Date: 17 July 2023

Our ref: 62047/01/DL/ERo/26800957v1

Cherwell District Council: Begbroke Science Park, Begbroke Hill, Begbroke, Kidlington, OX5 1PF – Non-Material Amendment to Condition 17 of Outline Planning Permission ref. 18/00803/OUT

drawing number: LP2264-FIR-00-ZZ-DR-L-0010

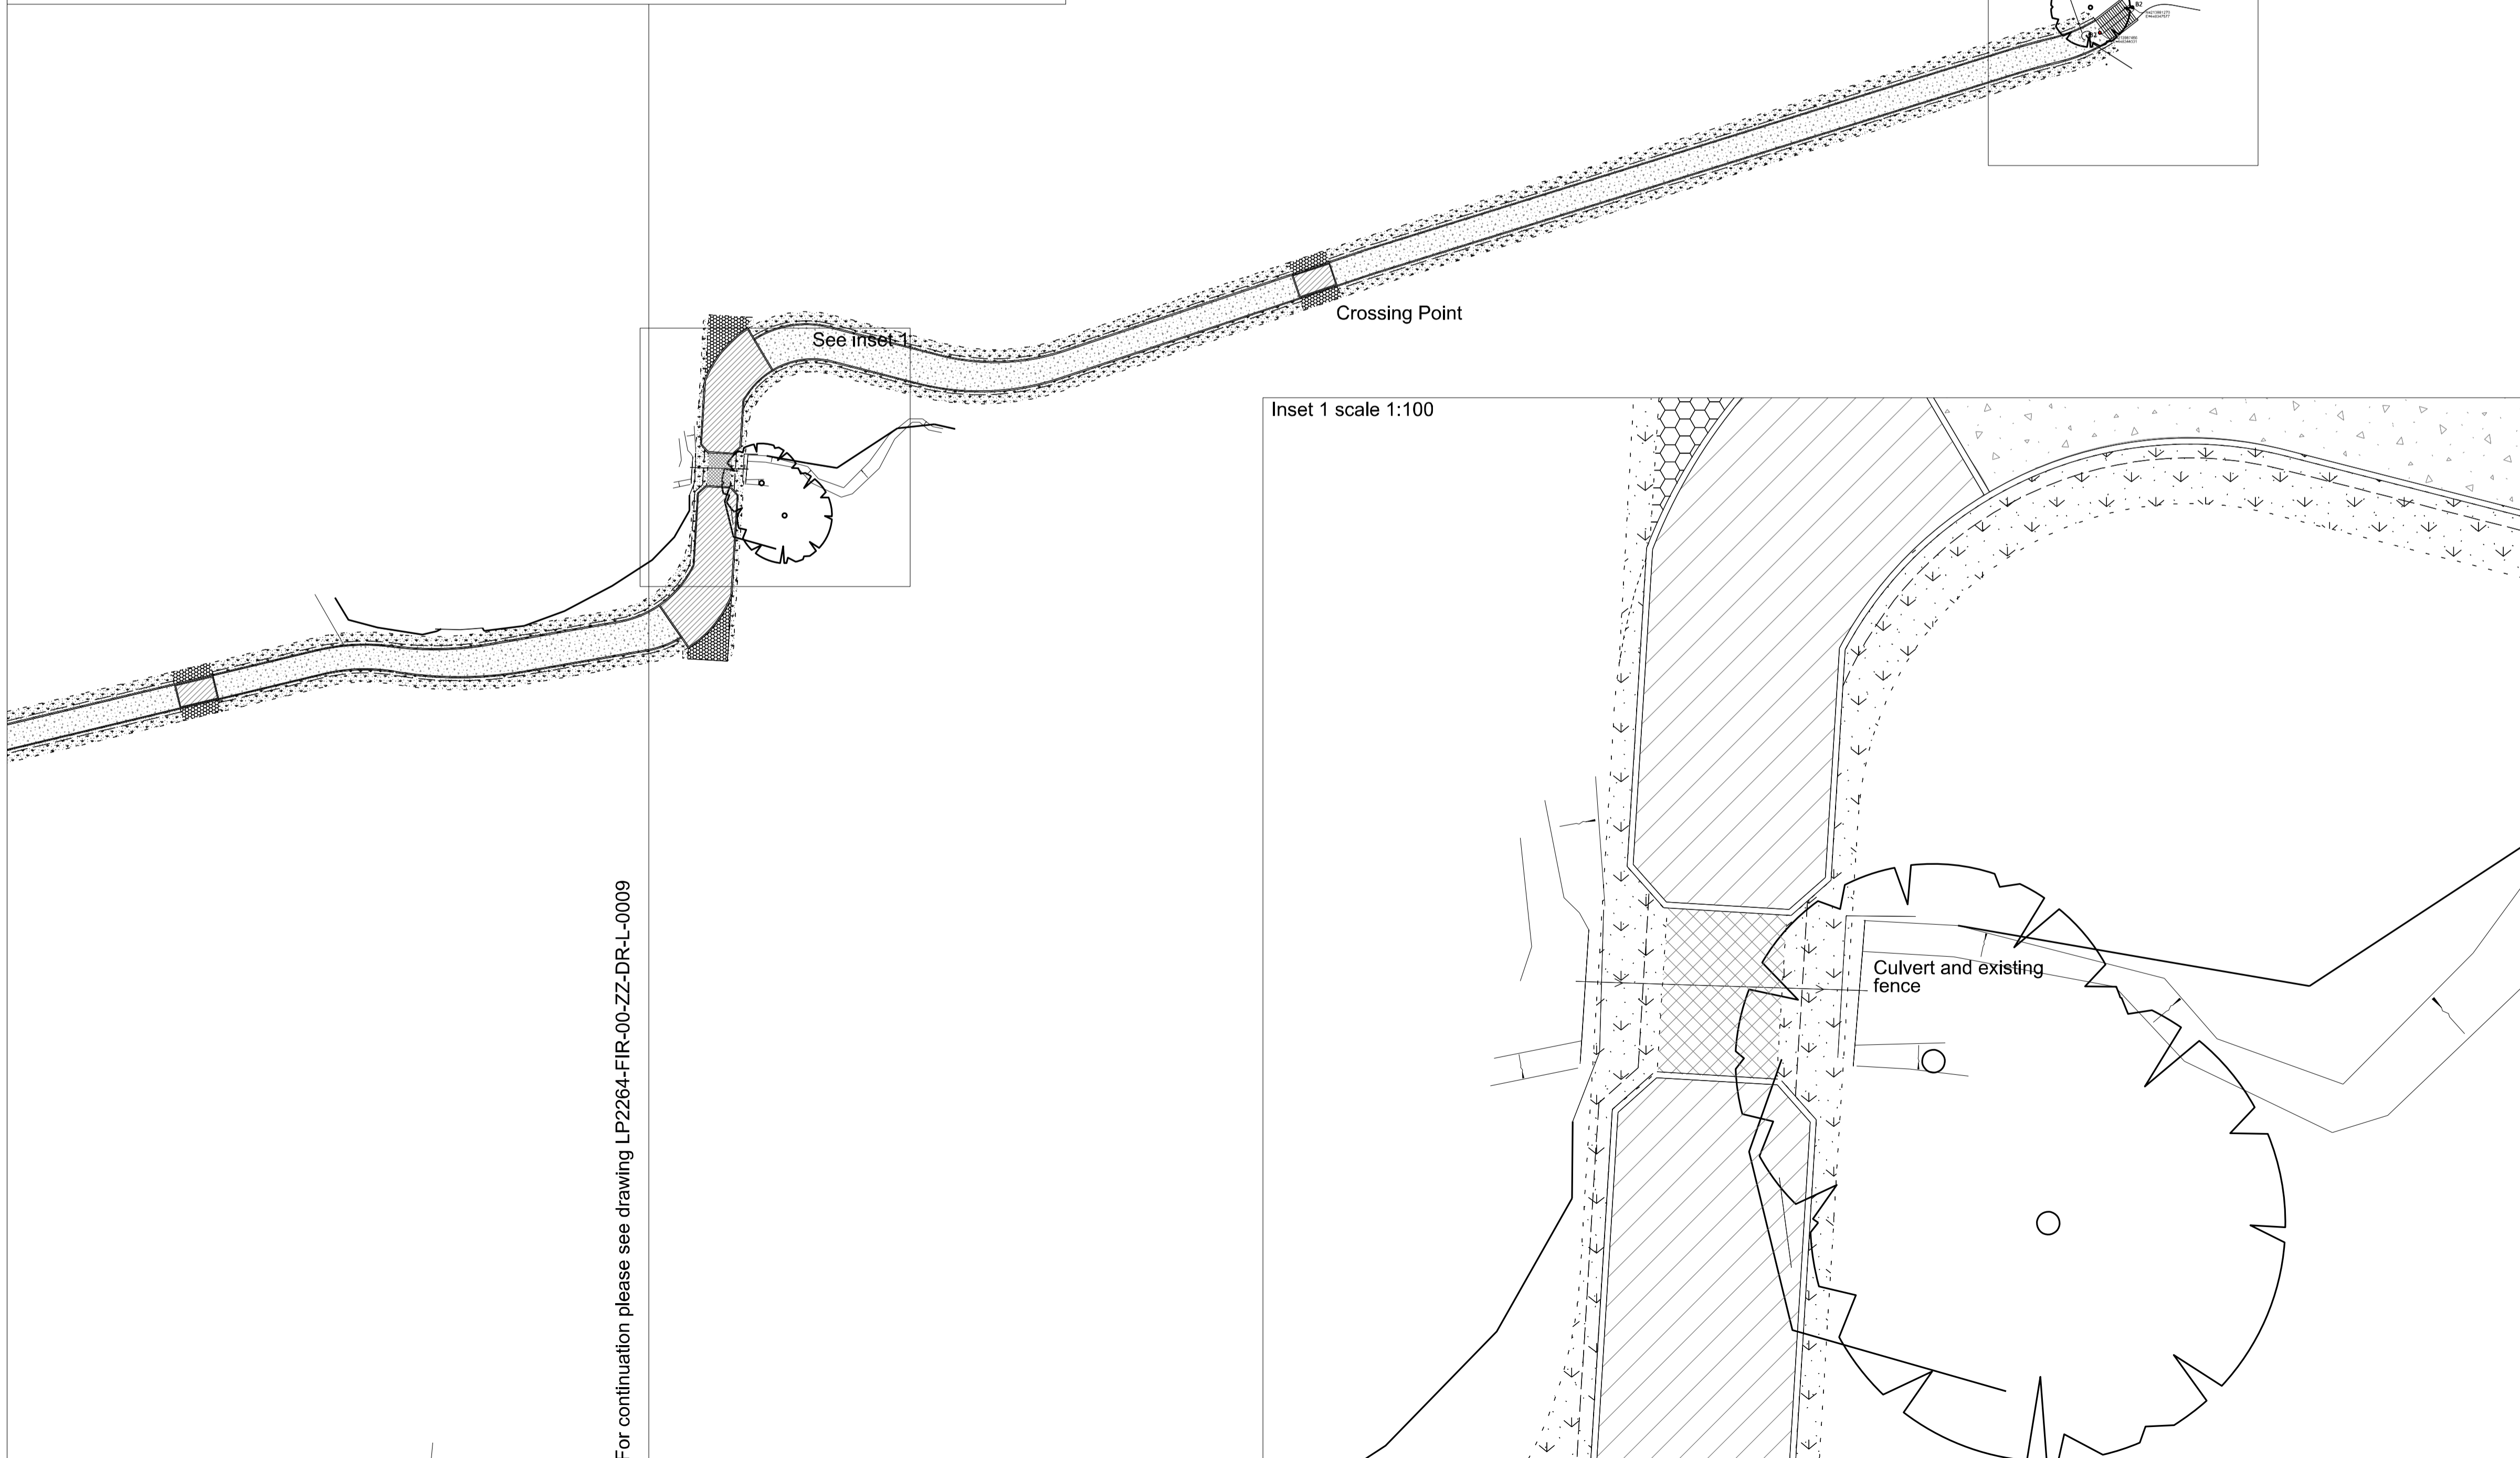
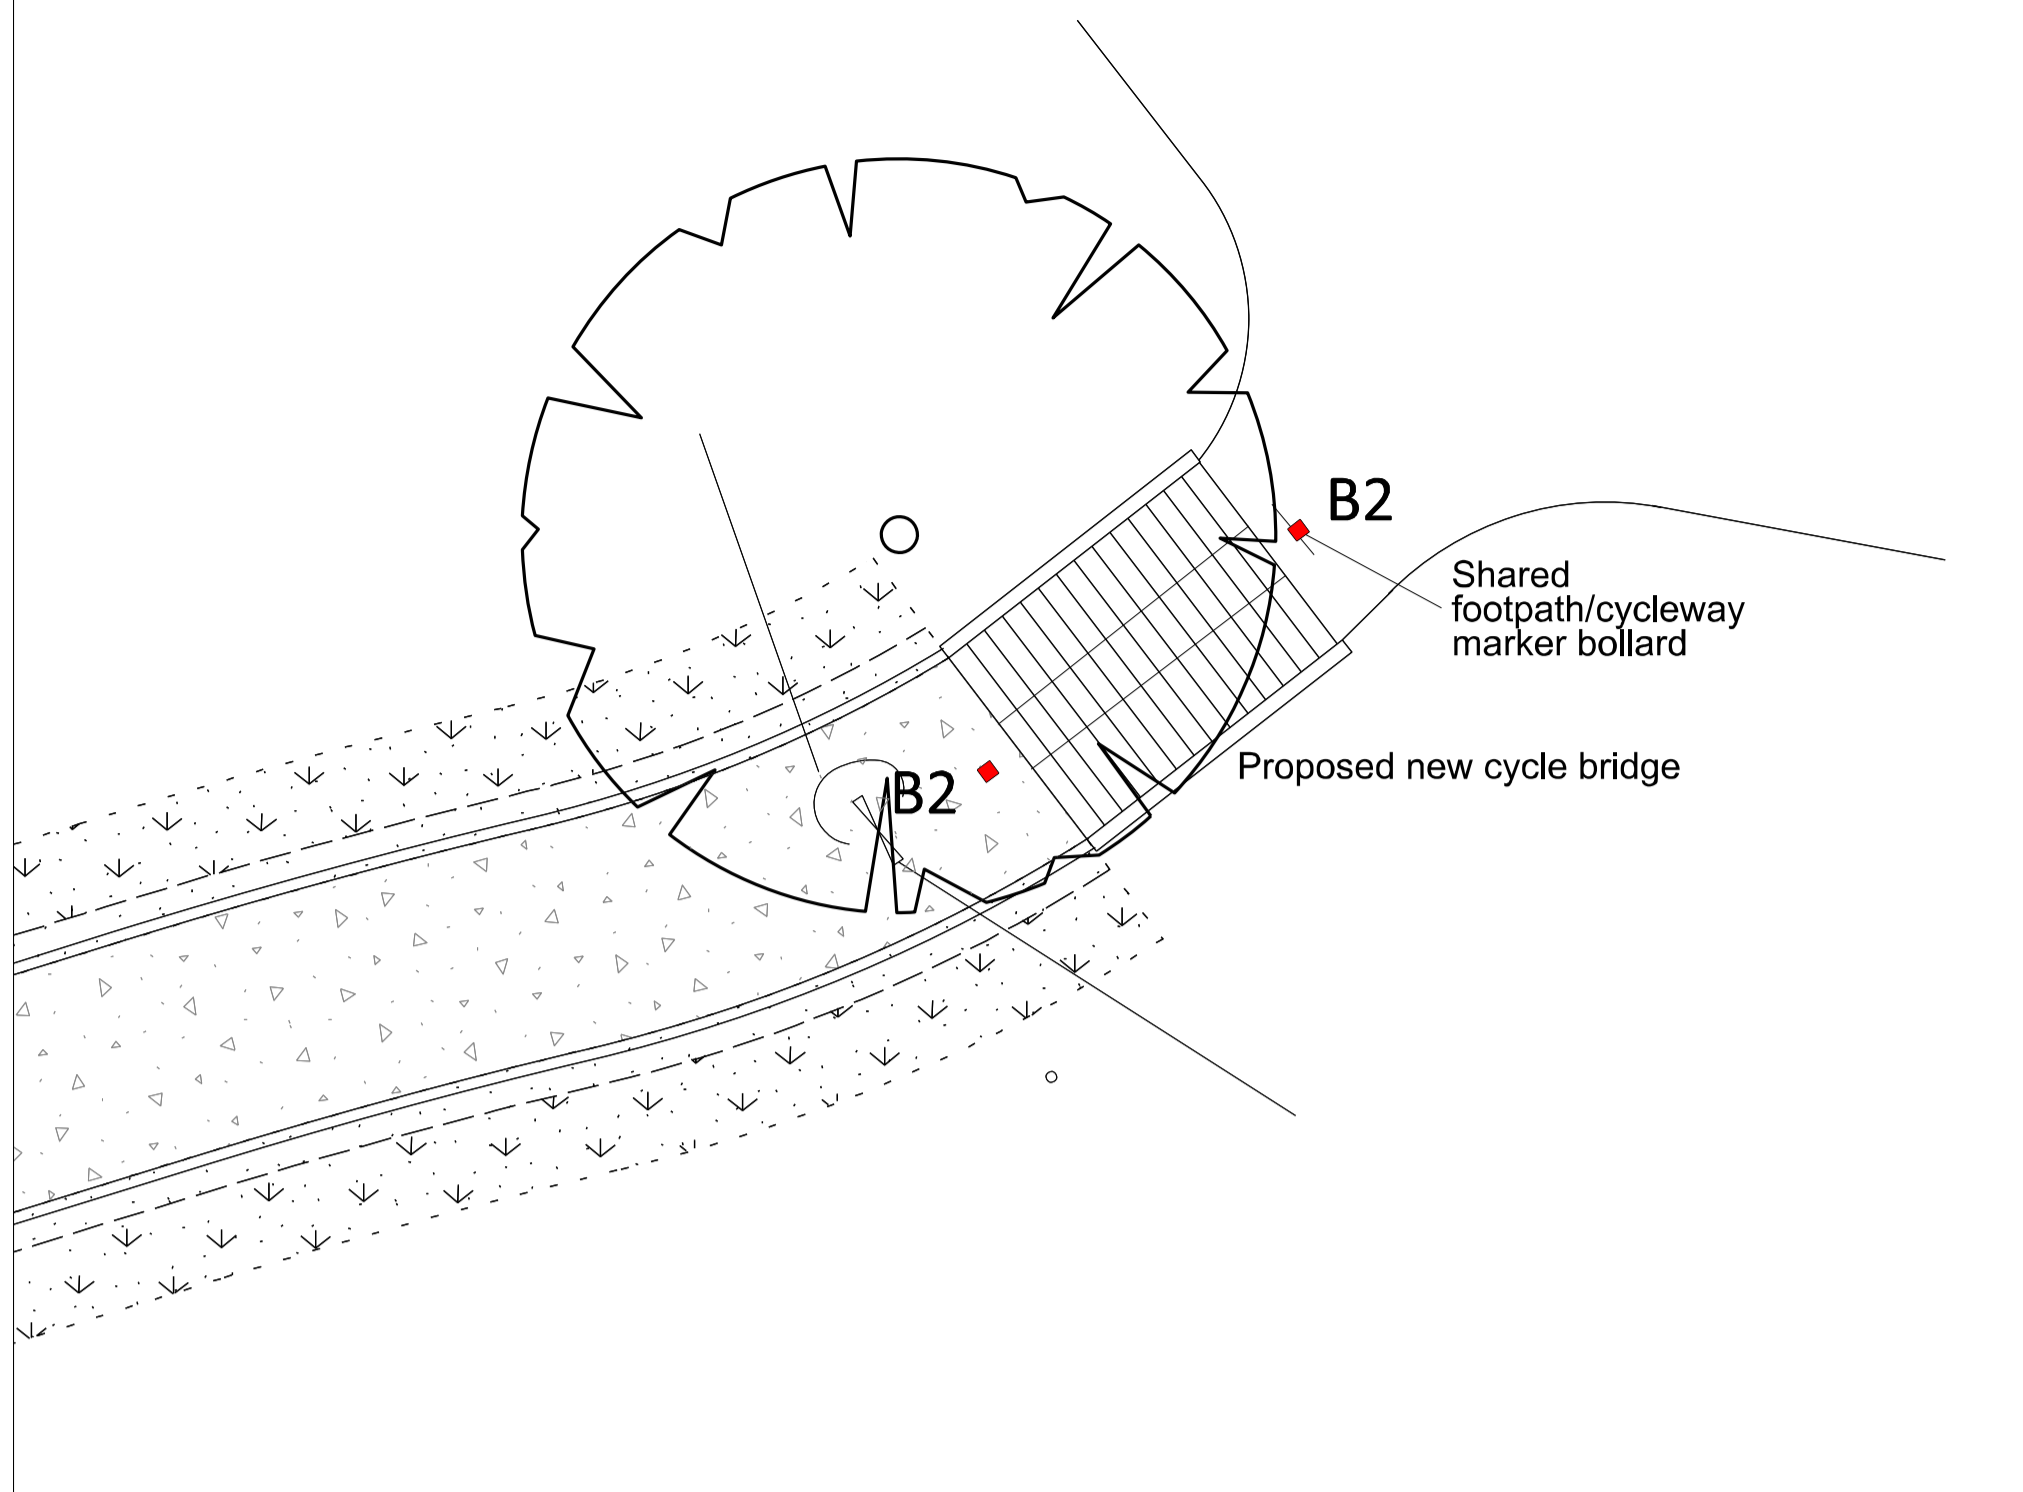
The revised drawings remove the fence on either side of the permissive cycle path and footpath other than over the bridge but include two new bollards, one on the internal side of the bridge and another by Begbroke Campus, to deter vehicle access.

- *LP2264-FIR-00-ZZ-DR-L-0009 P02*
- *LP2264-FIR-00-ZZ-L-0010 P02”*
